Subject: Nursery Fields Land to the North of Chalcraft Lane West Bersted PO21 5TS - BE/148/20/OUT

Planning Application Reference: BE/148/20/OUT

Proposal: Outline application with some matters reserved to provide up to 225 residential units with associated infrastructure, open space and vehicular and pedestrian access. This application affects a Public Right of Way

Submitted Parameter Plan - drawing reference 01304_Building Heights Parameter Plan_PP_03_PI

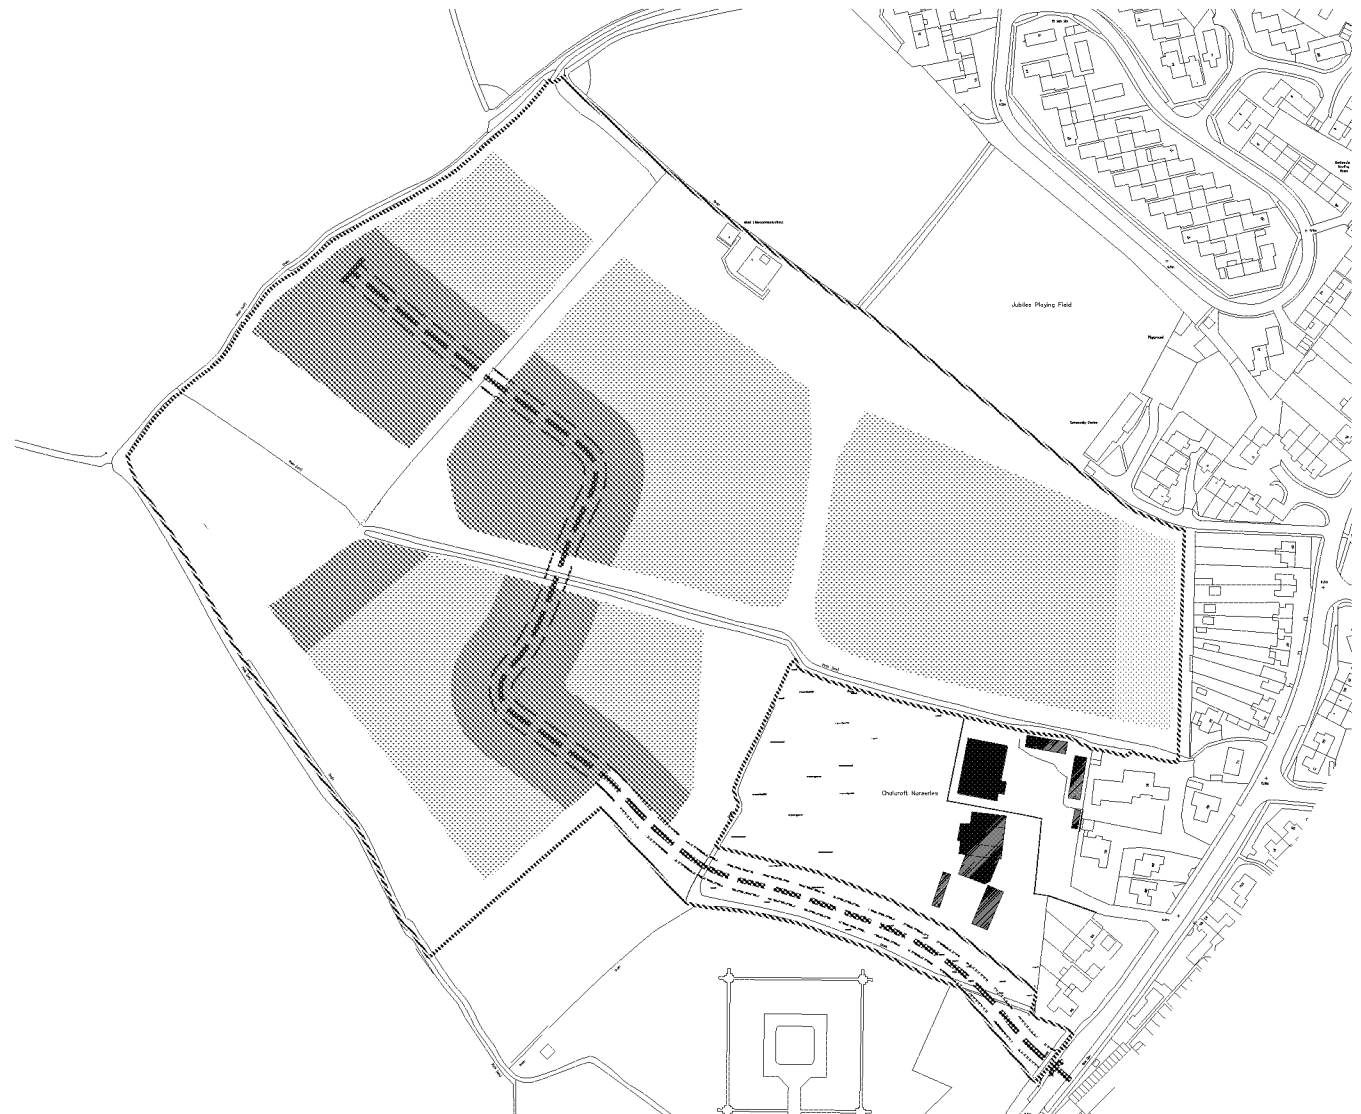
I note from the submitted document 'Building Heights Parameter Plan 01304_PP-03 REVP1', that the primary vehicular route will be lined with 3 storey houses. This has the potential to create an urban canyon and introduce high concentrations of NO^x produced by traffic, which is detrimental to Air Quality and will increase human exposure to air pollution. I therefore recommend that the design and layout of the development is such that an urban canyon is not created.
